RE: New Public School in Googong SSD RFI

Reference is made to the response submissions from the Department of Planning, Industry and Environment (DPIE), - Queanbeyan-Palerang Regional Council and Transport for NSW (TfNSW) with respect to SSDA submission for the new school in Googong (Reference SSD – 10326042).

Table 1 DPIE RtS Letter

OVERALL SITE FENCING PAN 1  
1: 500 80, 401

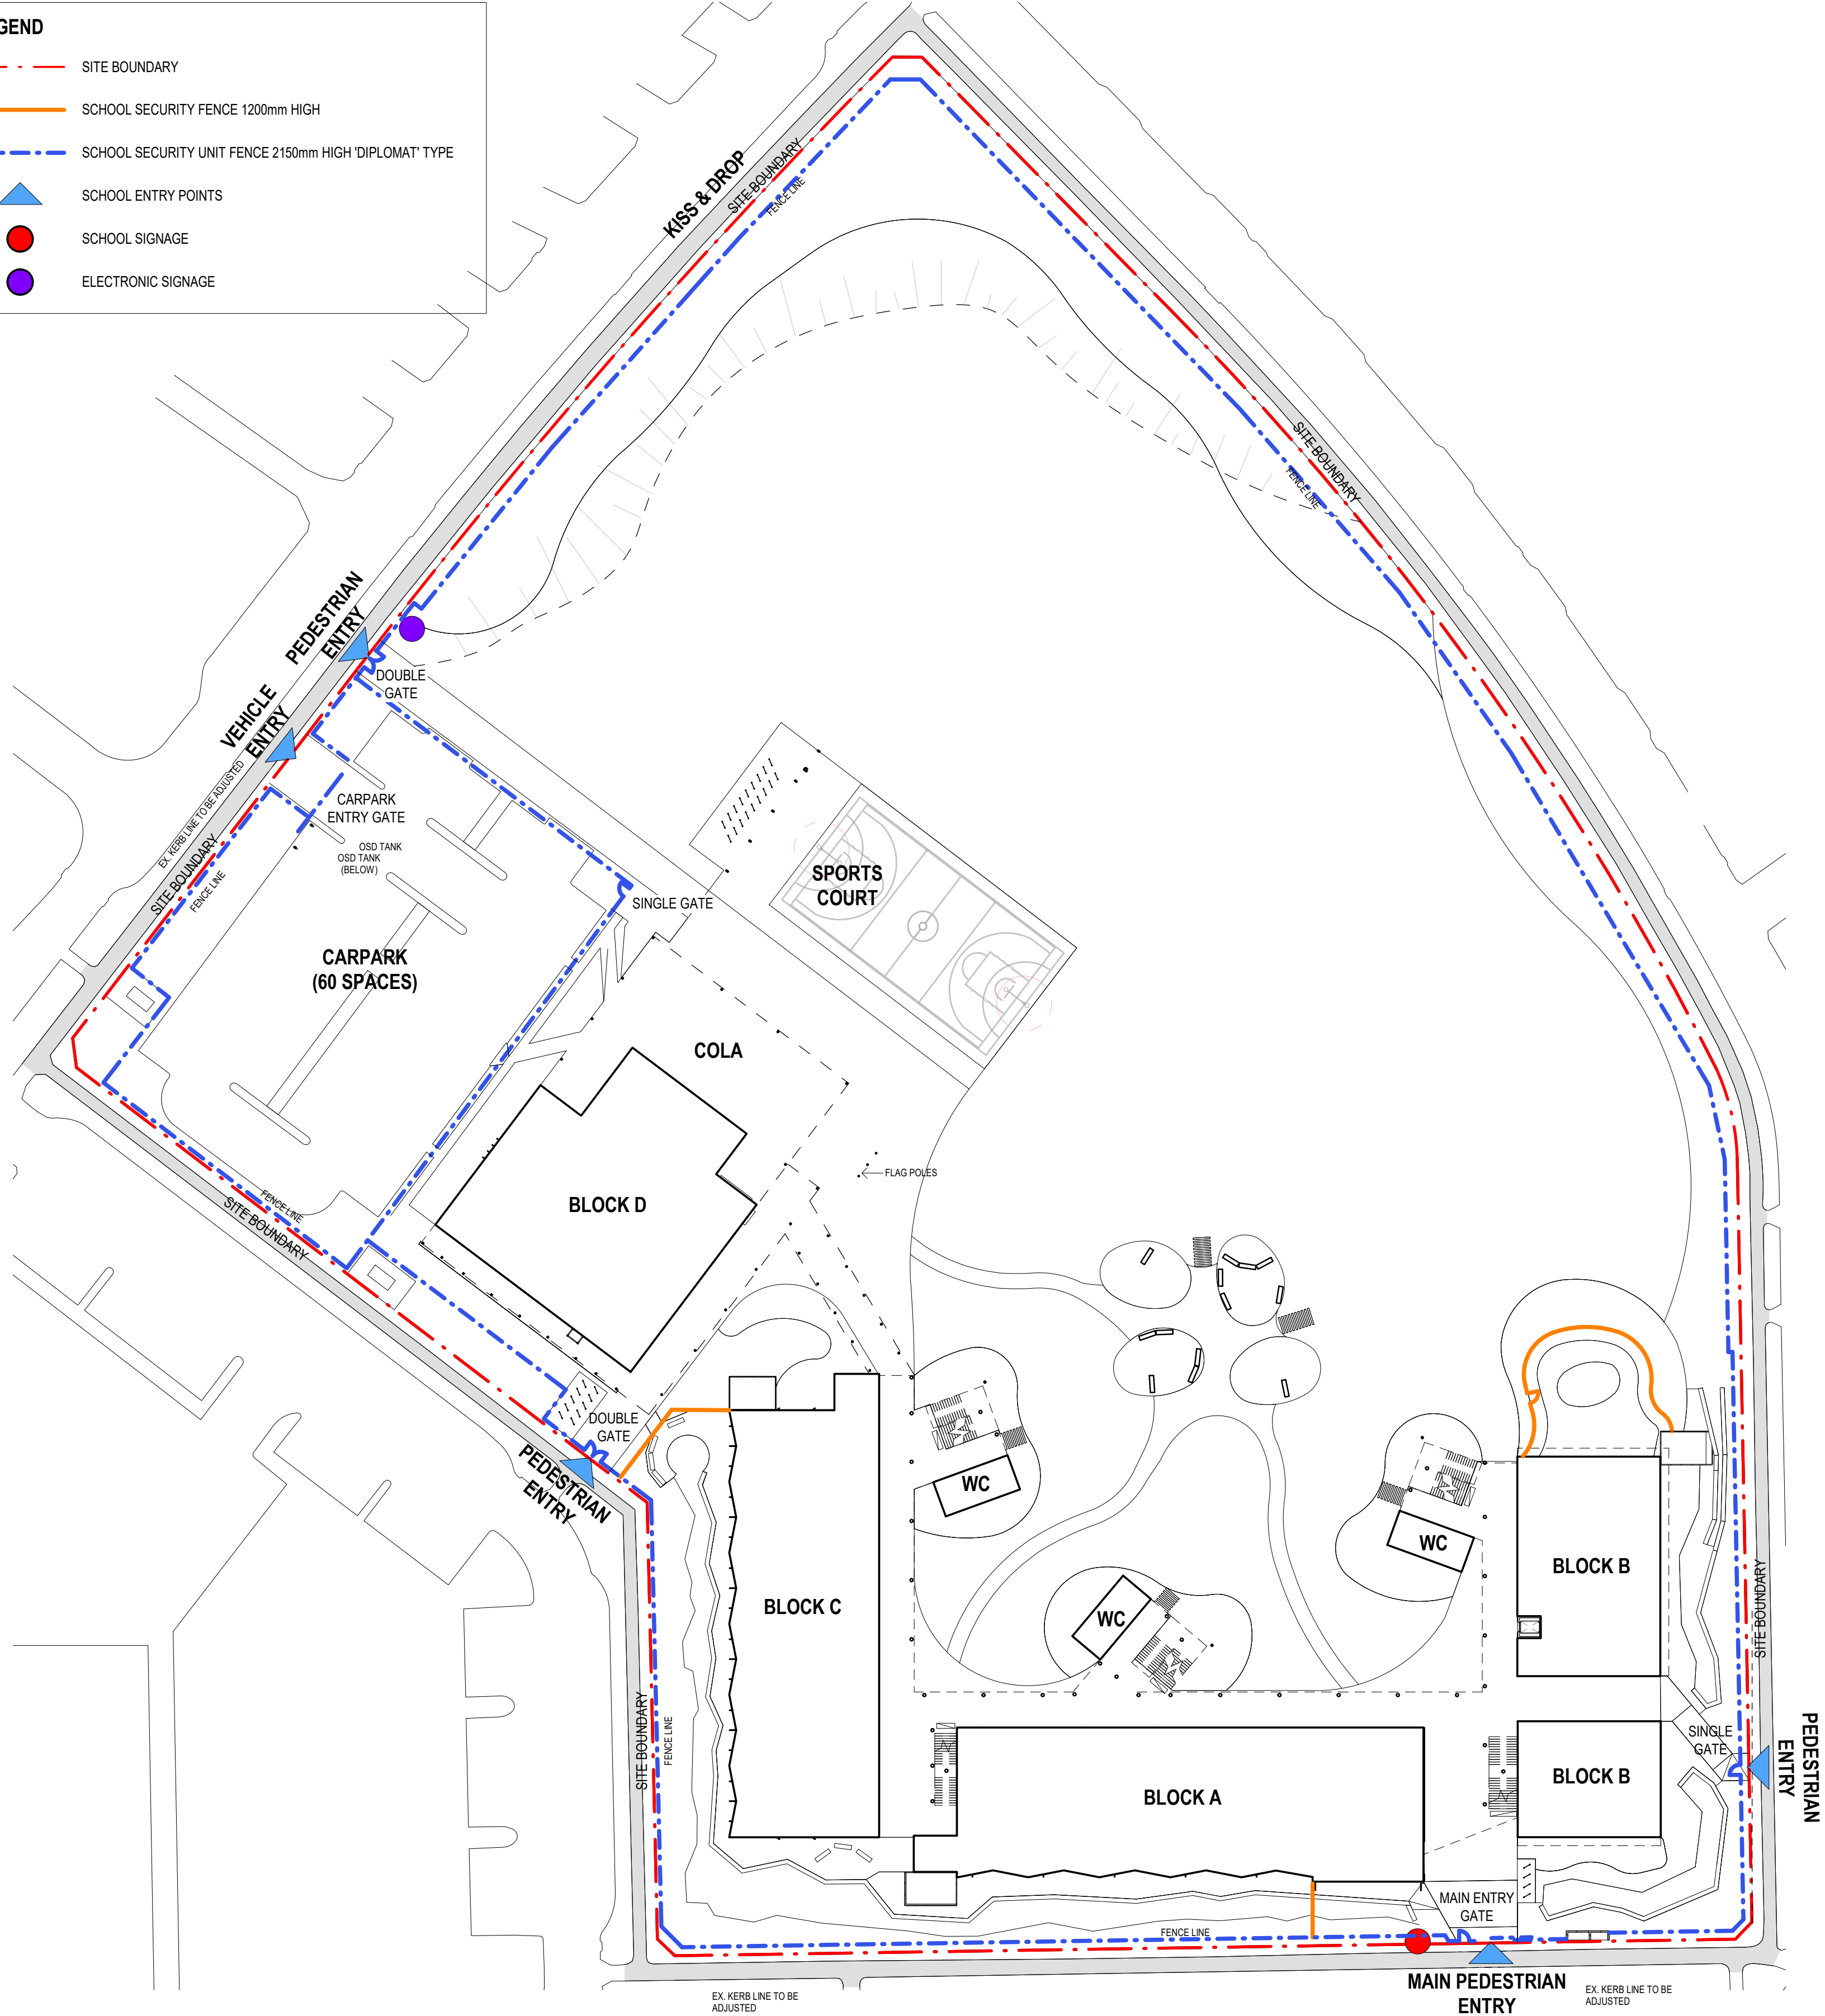
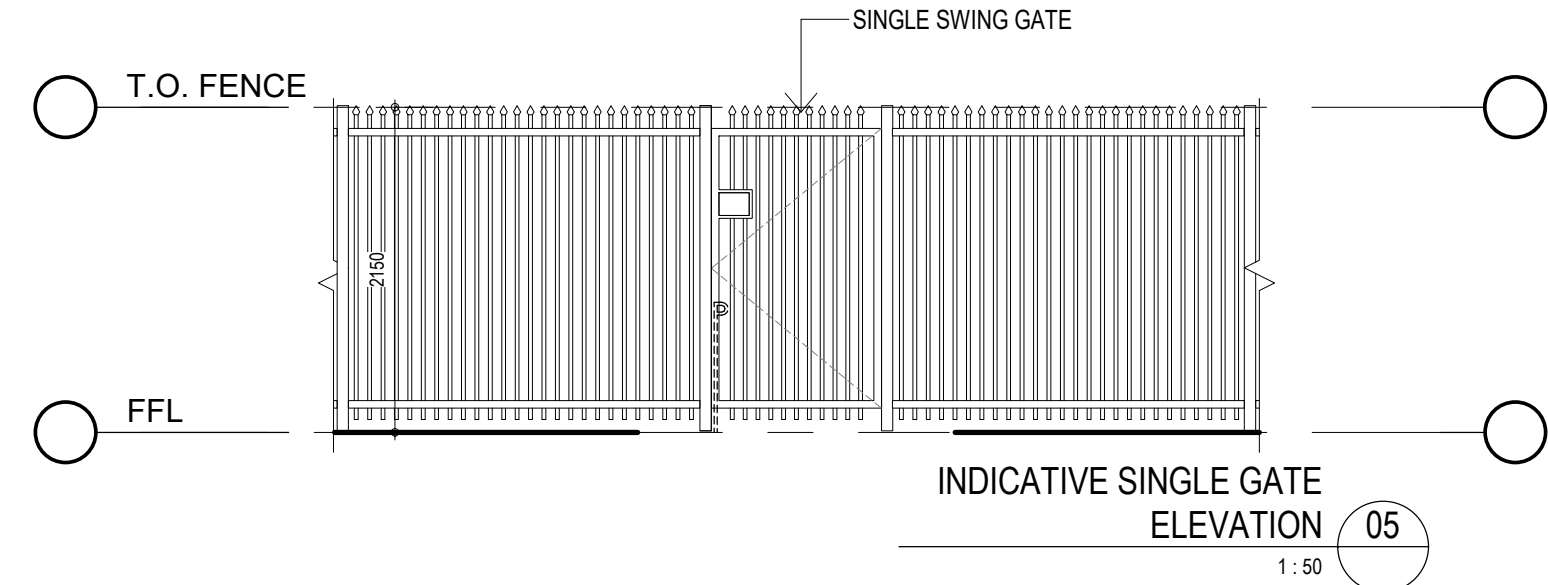
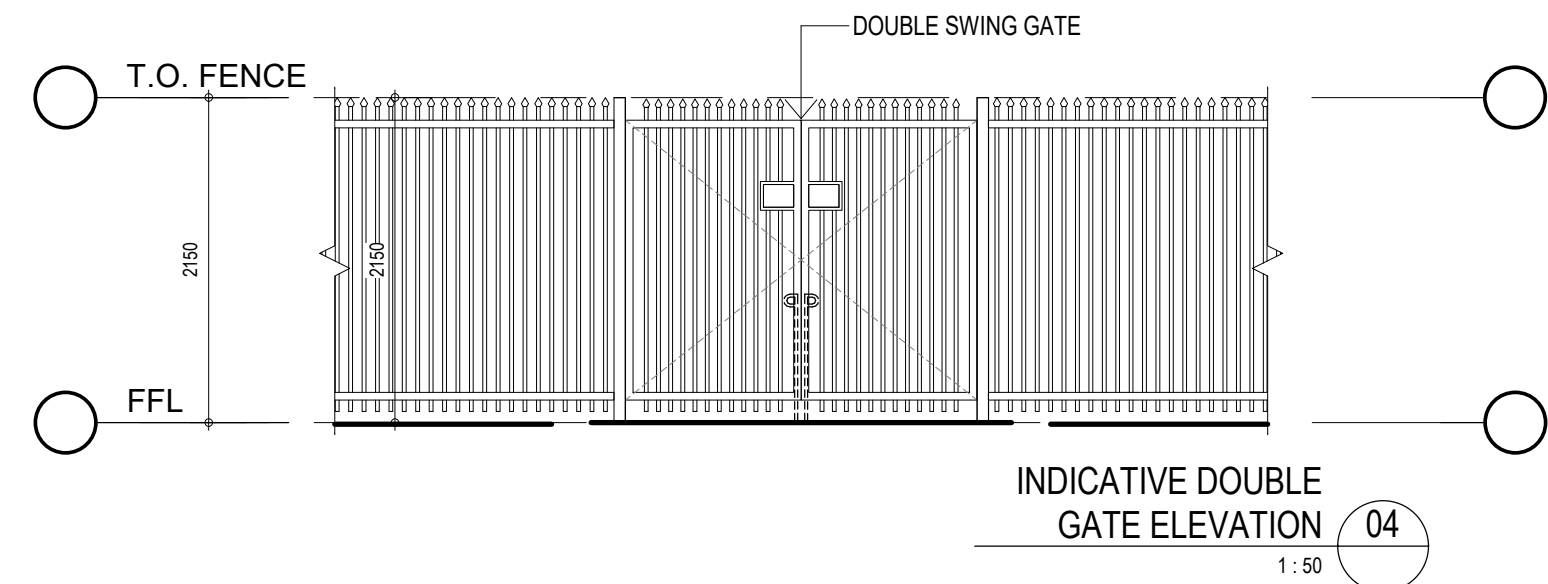
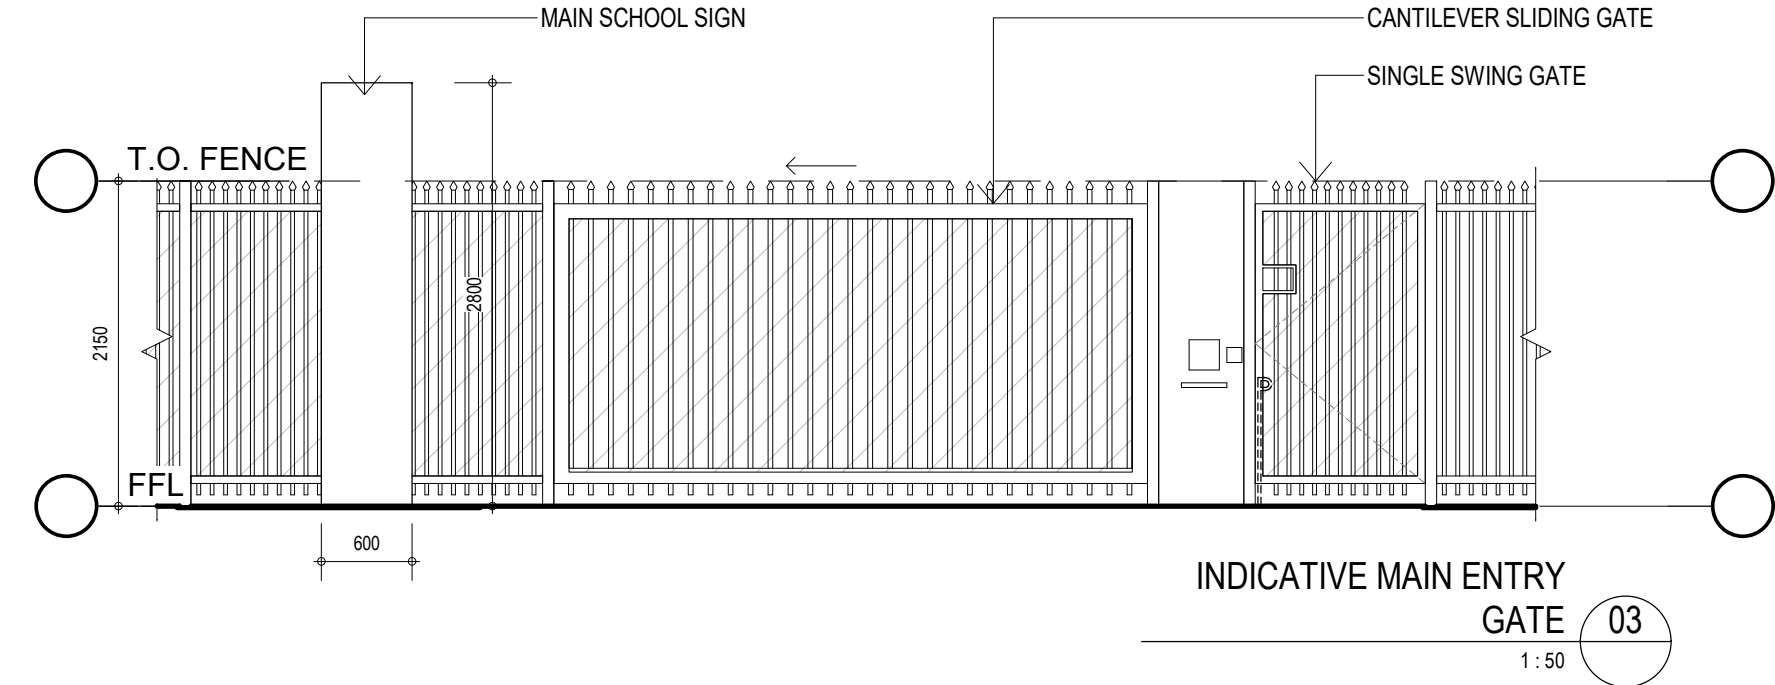
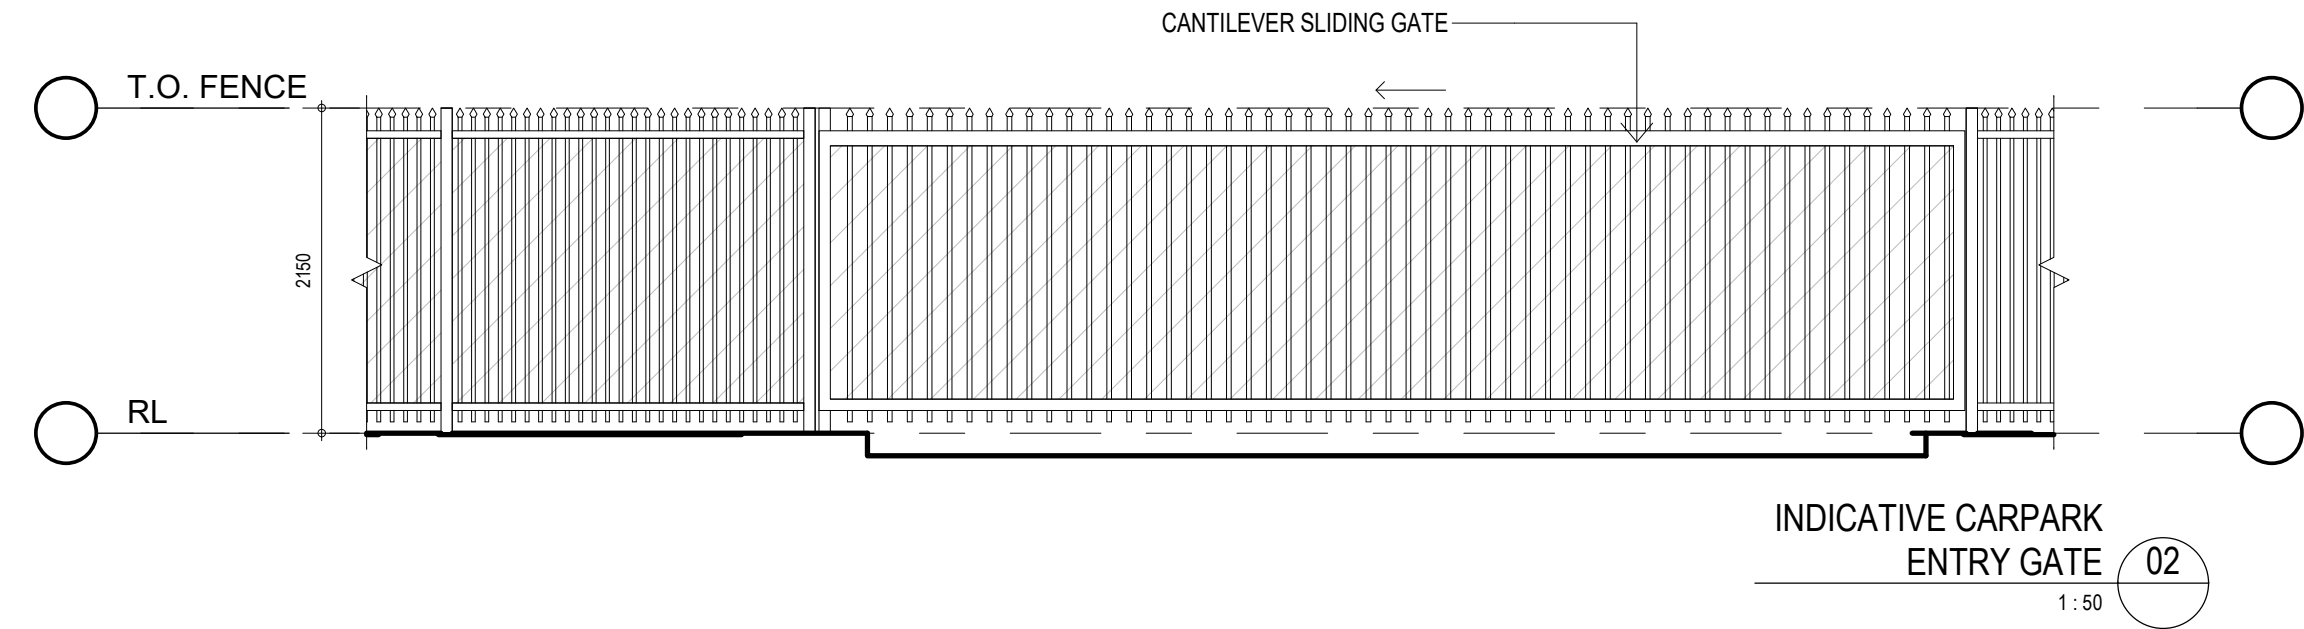
1.3	<p>The number of access points and pedestrian crossings along with locations of crossings adjacent to intersections are not supported. Council's position on this is echoed in feedback provided by TfNSW, extracts below;</p> <p><i>e) Assess and justify the number of access points required to and from the school. TfNSW notes that the concept site plan (Figure 2.1 in the GHD report) shows five pedestrian access points to the school. TfNSW would encourage limiting the number of access points to three (e.g. one on each frontage except McPhail Way). An initial review has indicated that as there is a pedestrian and vehicle generator on McPhail Way with the shops and car parking. An entrance on this side could cause safety concerns as well as increased congestion. TfNSW also suggests that the main entrance to the school be provided via Wilkins Way and not Gorman Drive. This is due to crossings and main entries being avoided on sub arterial roads or roads with greater than 2,000 annual average daily traffic (AADT);</i></p> <p><i>f) Reduce/consolidate the number of children's crossings. TfNSW notes that the concept/site plan provided shows 6 crossings. Any crossing provided should be strategically located to be safe and accommodate desire lines. Where possible raised zebra crossing shall be used with no crossings installed at junctions. Details are also required on how the</i></p>	<p>TfNSW in their EIS response (dated 2 July 2021), provided the following response with respect to the proposed pedestrian crossings:</p> <p><i>"a) Any new pedestrian crossing to be provided should be raised to slow vehicle speed in line with the safe systems approach (i.e. wombat crossing). The design should comply with Austroads Guide to Road Design and Guide to Traffic Management including applicable supplements.</i></p> <p><i>b) The details on the proposed pedestrian crossings shall be submitted to the Queanbeyan-Palerang Regional Council Local Traffic Committee for review and comment before the submission of a detailed design to Council as part of obtaining Section 138 approval under the Roads Act 1993."</i></p> <p>Of importance, the referral response did not raise any concerns with respect to the number of pedestrian crossing nor the number of access points to/from the school, only highlighting the need for any proposed pedestrian crossing to be submitted to the Queanbeyan-Palerang Regional Council Local Traffic Committee for review and comment.</p> <p>As per the most recent meeting with Council whereby additional mapping of de-personalised data was provided, it is anticipated that approximately 150</p>

The rationale of having multiple entrances for the school site to promote pedestrian access, is a principle Council supports. However, in practise existing schools within the area that have two entrances have seen principals typically opt to close one entrance in favour of managing one single entrance to the school. Council encourages reconsideration of a main access on Gorman Drive. The nearby Anglican School whilst fronting Gorman Drive has their access aligned with the off-street parking and pick up/drop off area on Rosa Street. Similarly, Queanbeyan East Public School have closed their access via Yass Road and have their main access points on minor local roads like Thurralilly and Mulloon Streets.

Given the above it is Council's view that the number of access points should be minimised.

The application plans have been revised to 5 pedestrian crossings following most recent consultation with Council. Whilst their locations do not all currently warrant formalised crossings (zebra or children's), it is envisaged that once the school is in operation the warrants will be met based on the origin / destination of students.

<p>Acknowledging that TfNSW requires all proposed pedestrian crossings to be raised, the above material indicates that the accident reduction for a raised pedestrian crossing is 80%. As such, it is our recommendation that all of the proposed pedestrian crossing locations be adopted and endorsed.</p> <p>However, if any of the proposed pedestrian crossings are to be removed, we request that Council provide a diagram of which ones are to be removed.</p>
